Householder Application for Planning Permission for works or extension to a dwelling.
Town and Country Planning Act 1990

GARAGE EXTENSION

project: GARAGE EXTENSION
GRANVILLE LODGE , GRANVILLE STREET
BARNLSLEY S75 2TQ
for R. BURTON
scale 1:50/100 at A1
drawing no PA02B

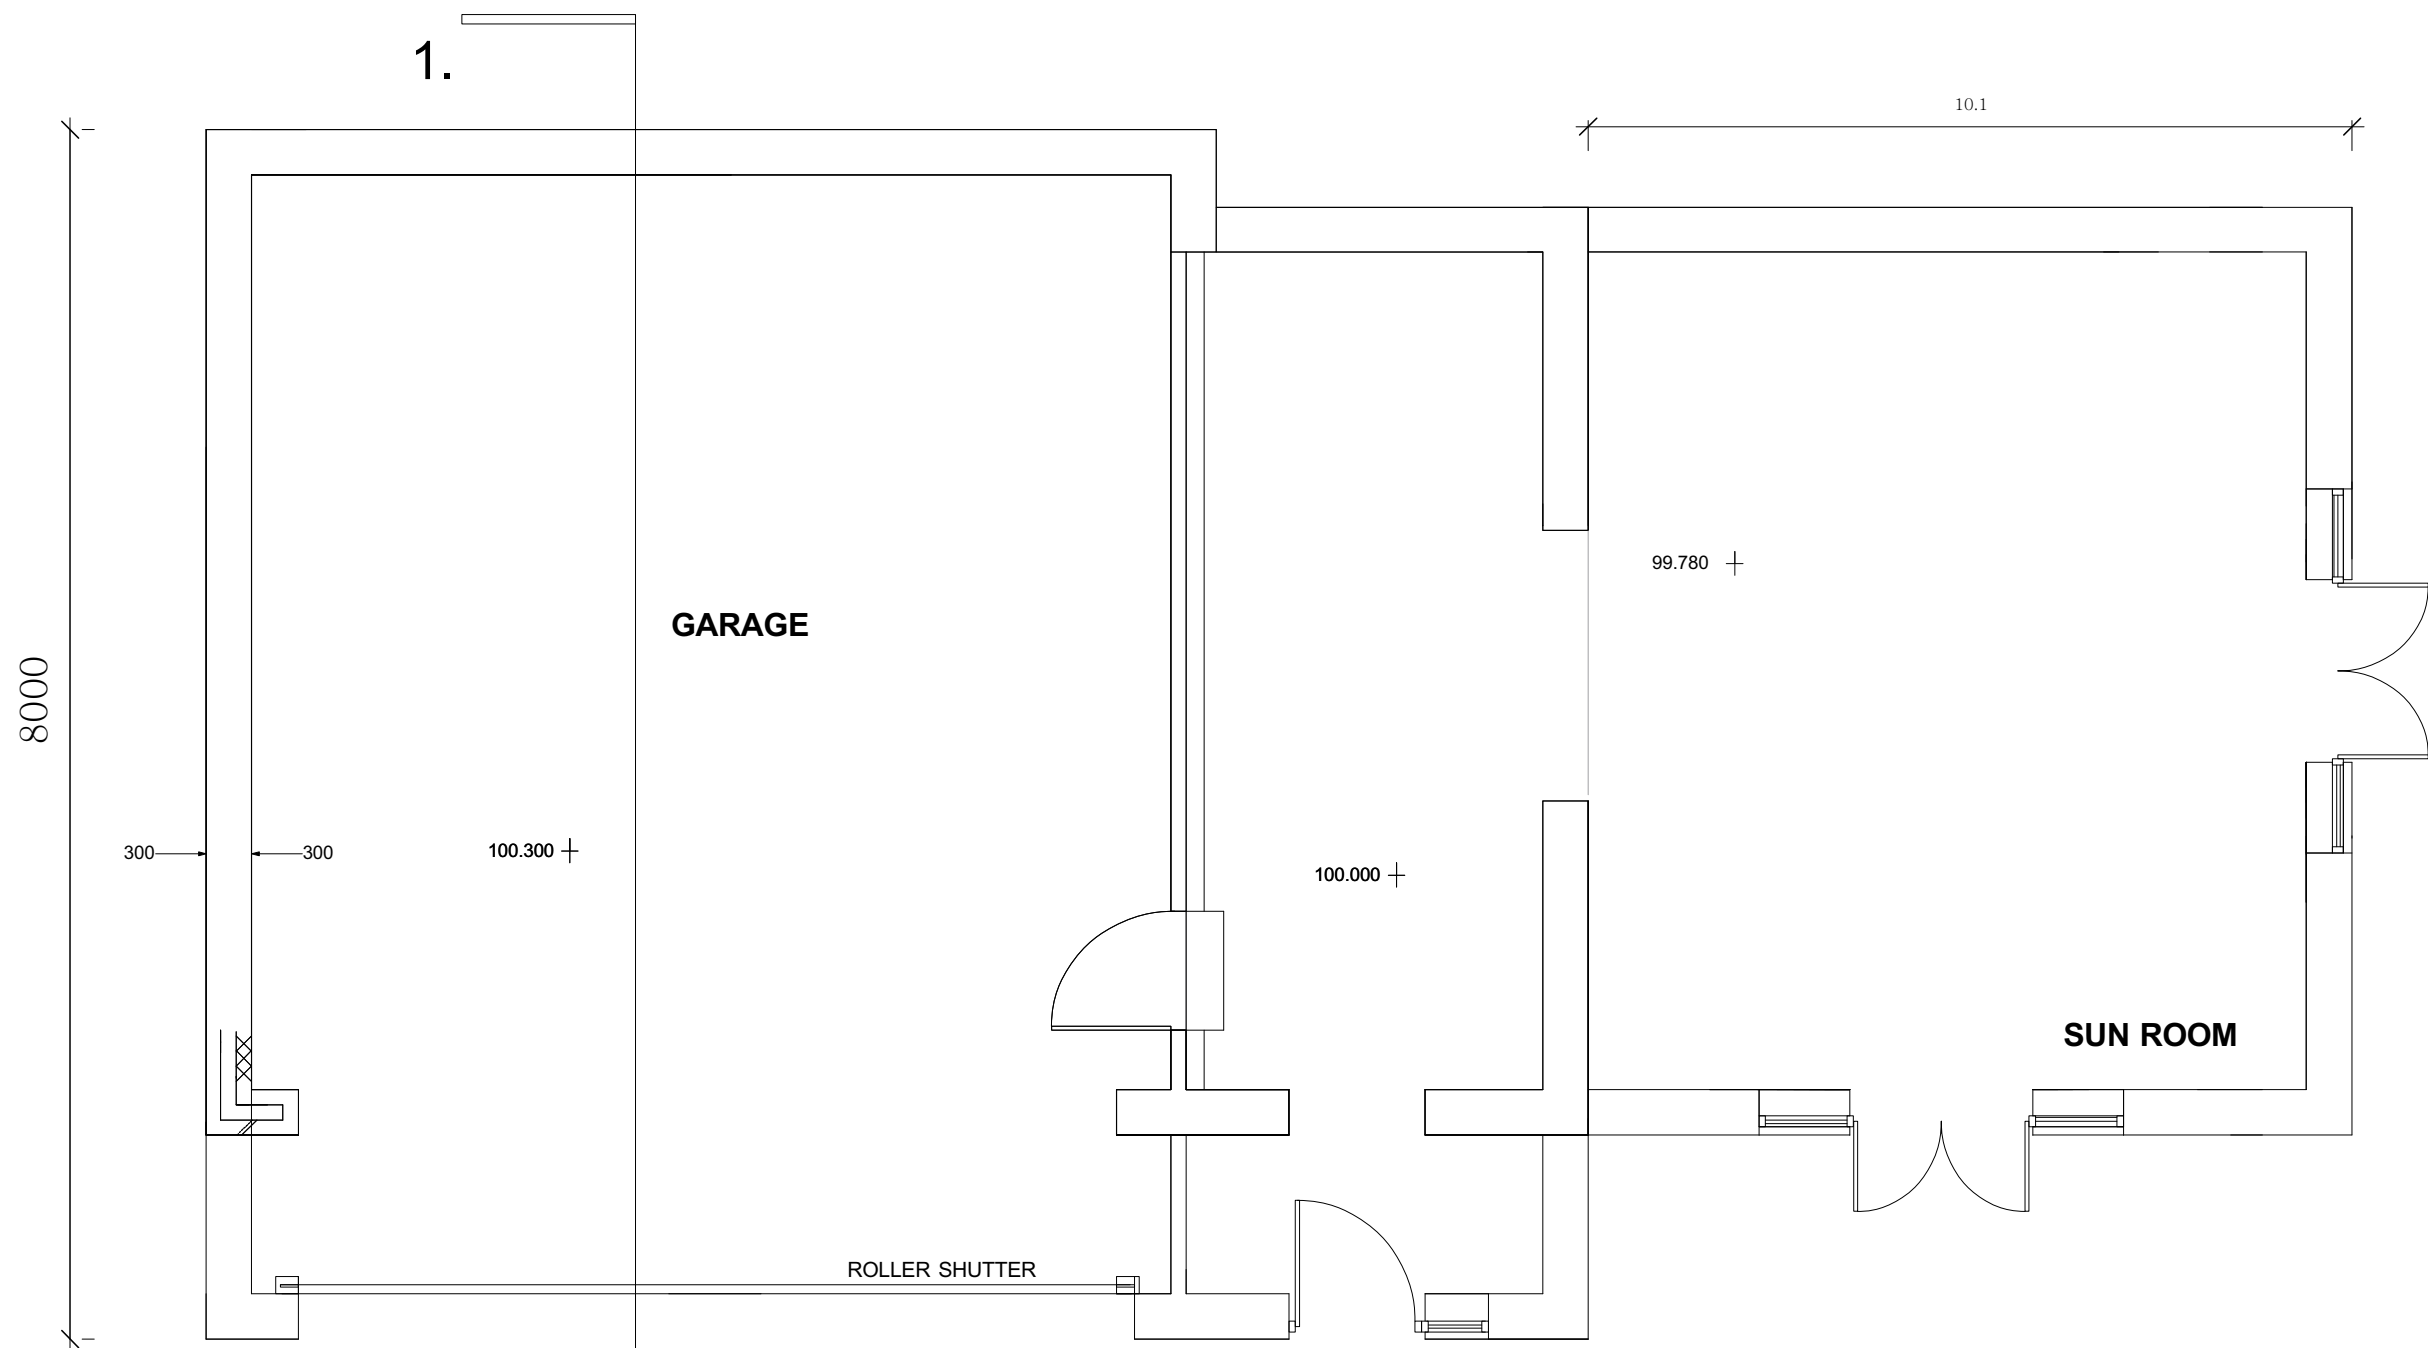
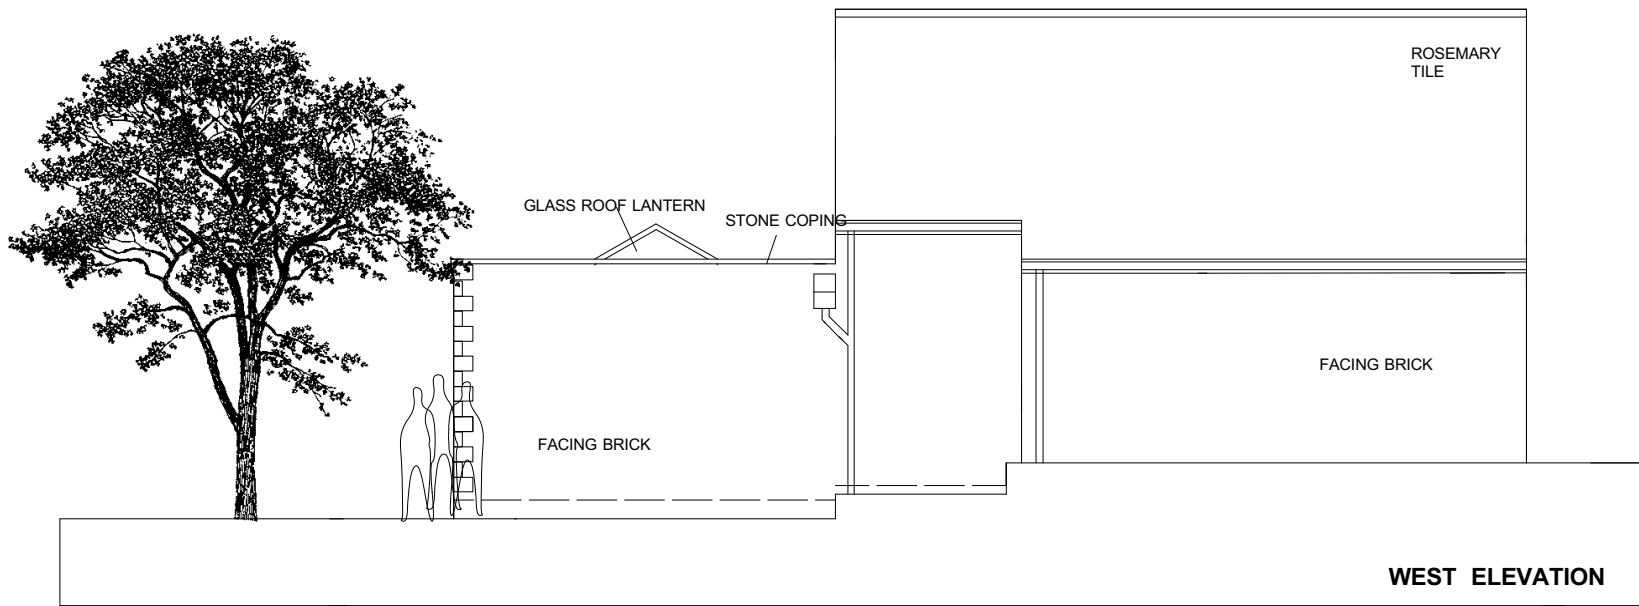
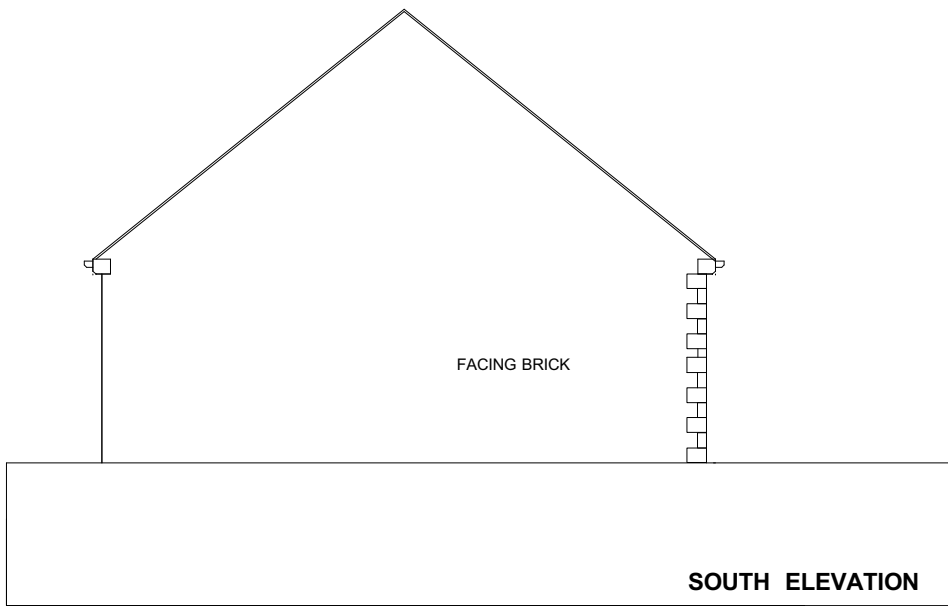
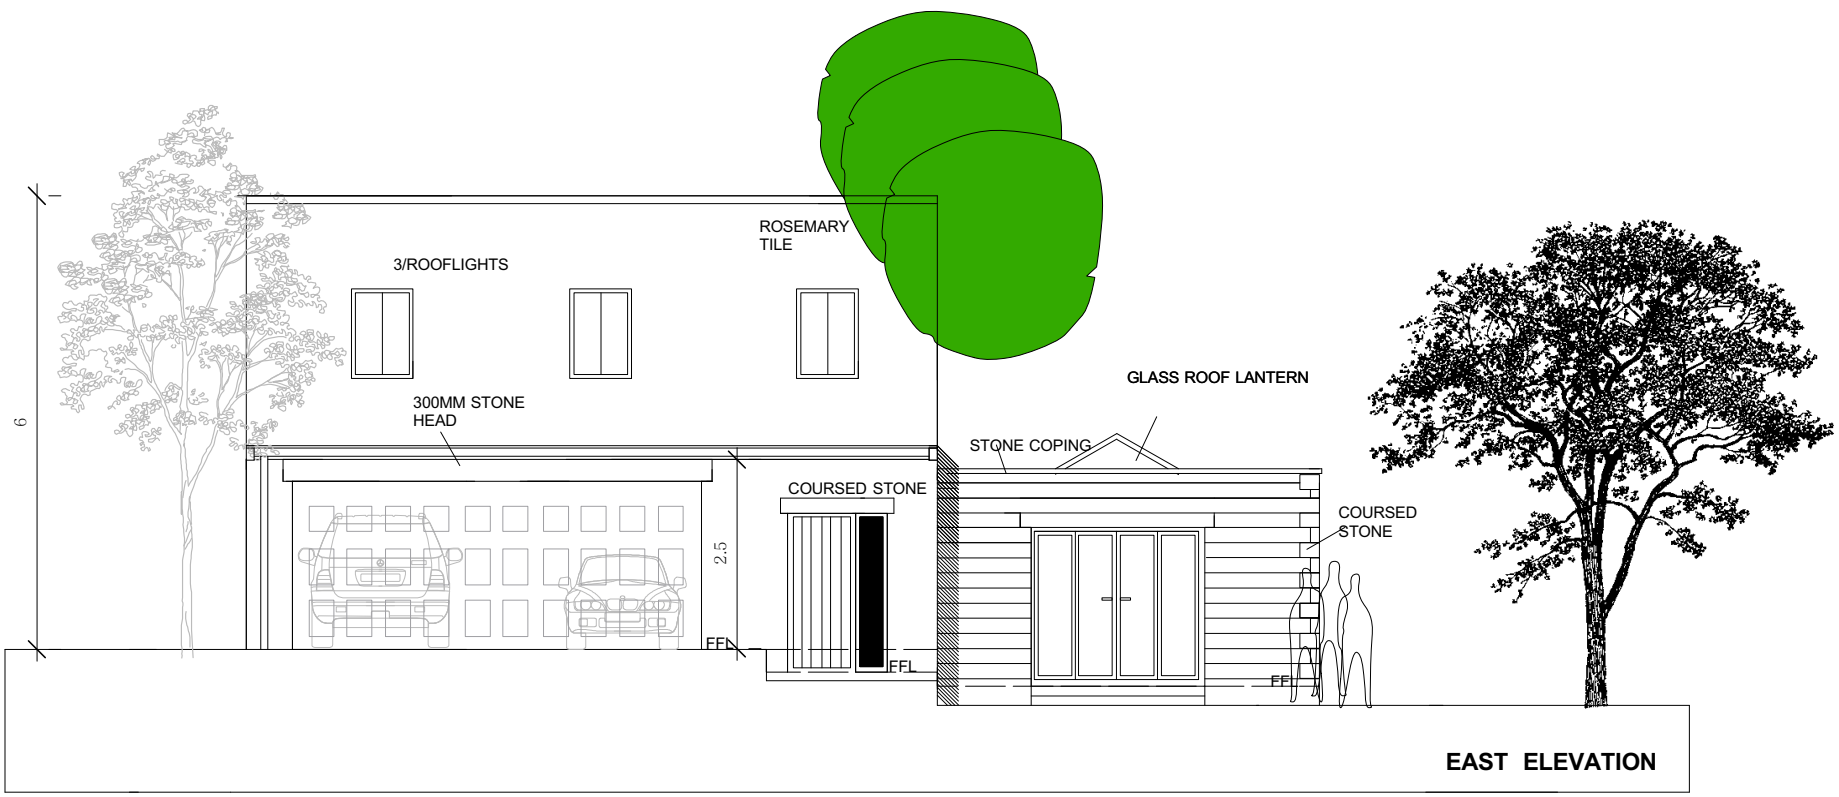
As I have previously stated, whilst I have not made a site visit, I am concerned that the proposed garage may have an adverse impact on neighbours in terms of overshadowing/overbearing. I would say that the ridge height needs to be reduced to no higher than 6m and even then, a judgement would have to be made about the impact on the neighbours and its relationship to the main dwelling.

The proposed sun room is not PD as it is 3.4m high above ground level. For an outbuilding to be PD it would need (amongst other considerations) to have a maximum height to the eaves of 2.5m and a maximum overall height of 3m (for a flat roof). Furthermore, as the proposed building appears to be within 2m of the boundary, to be PD, it would need to be no higher than 2.5m.
